Reference No:	<b>2023/62/91220/E</b>
Site Address:	44, Spring Grove, Clayton West, Huddersfield, HD8 9HH
Description:	Erection of first floor side extension
Recommending Officer:	Edward Cheseldine

**DECISION – CONDITIONAL FULL PERMISSION**

## HOUSEHOLDER DELEGATED REPORT

A	11/07/23	Changed front elevation to stone	JHS	
Rev	Date	Revision notes	By	Check
DO NOT USE FOR CONSTRUCTION				
Client Michael Howard		Drawing Title PROPOSED ELEVATIONS		
Project Title FIRST FLOOR EXTENSIONS		Drawn JHS	Date 16/04/23	
		Checked	Date	
Scale	1:100			
DWG No.	23002-A-005		Revision	-

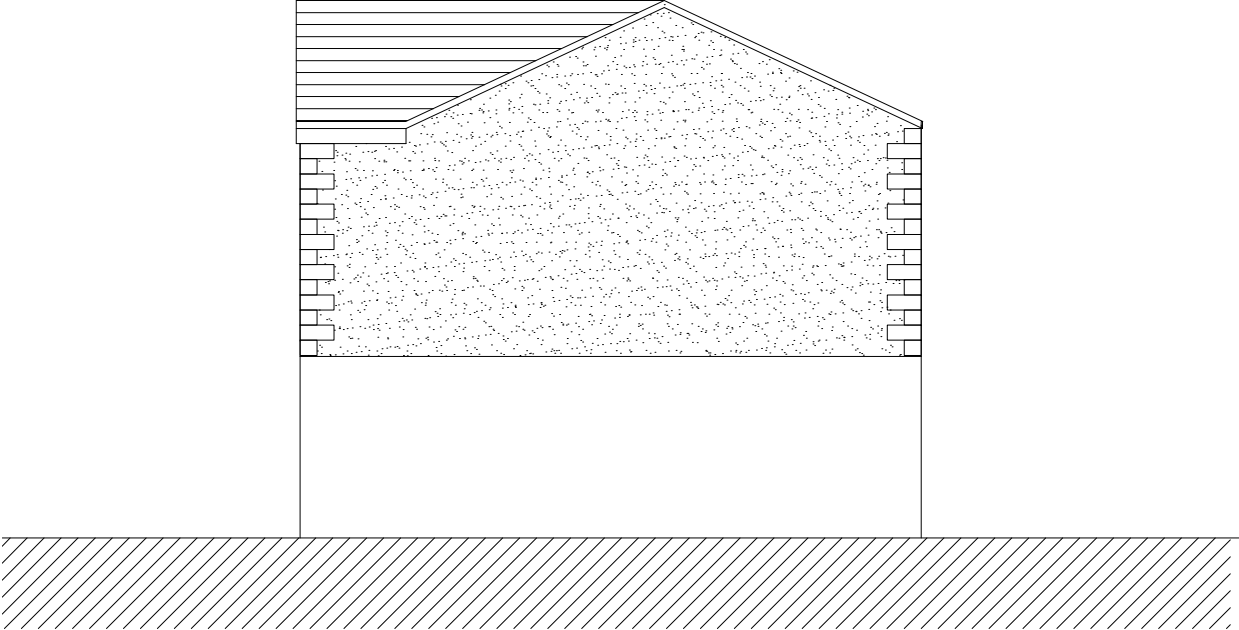
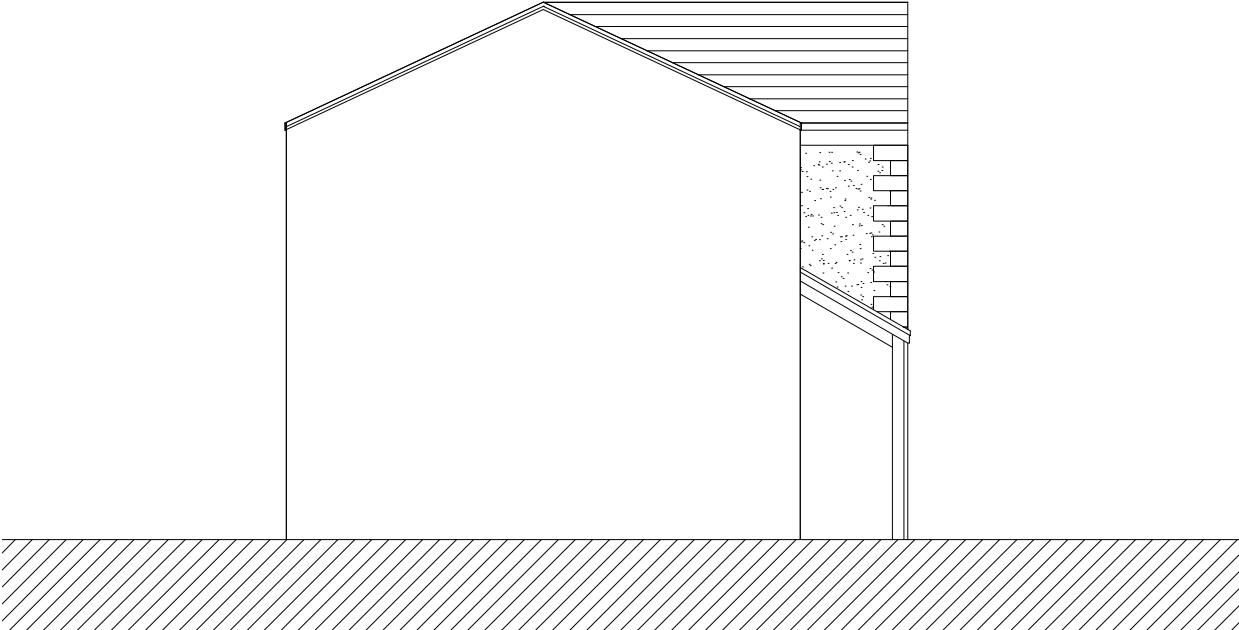
<b>YES / NO</b>	<b>SUMMARY</b>
Negotiations/Amendments during course of application	<b>Yes</b>	Negotiation between the planning officer and planning agent were sought over the materials of the extension as a render would contrast with the stone dwelling. Material amendments for the principal

elevation were conceded to match the stone frontage of the original dwelling.
Parish/Town Council comments sought	<b>Yes</b>	Denby Dale Parish Council – No comment.
Planning History		2002/91269 – Erection of conservatory, detached garage and alterations – Full permission granted.
Consultations required	<b>No</b>

3. The front facing wall and roofing materials of the extension hereby approved shall in all respects match those used in the construction of the existing building and thereafter be retained.
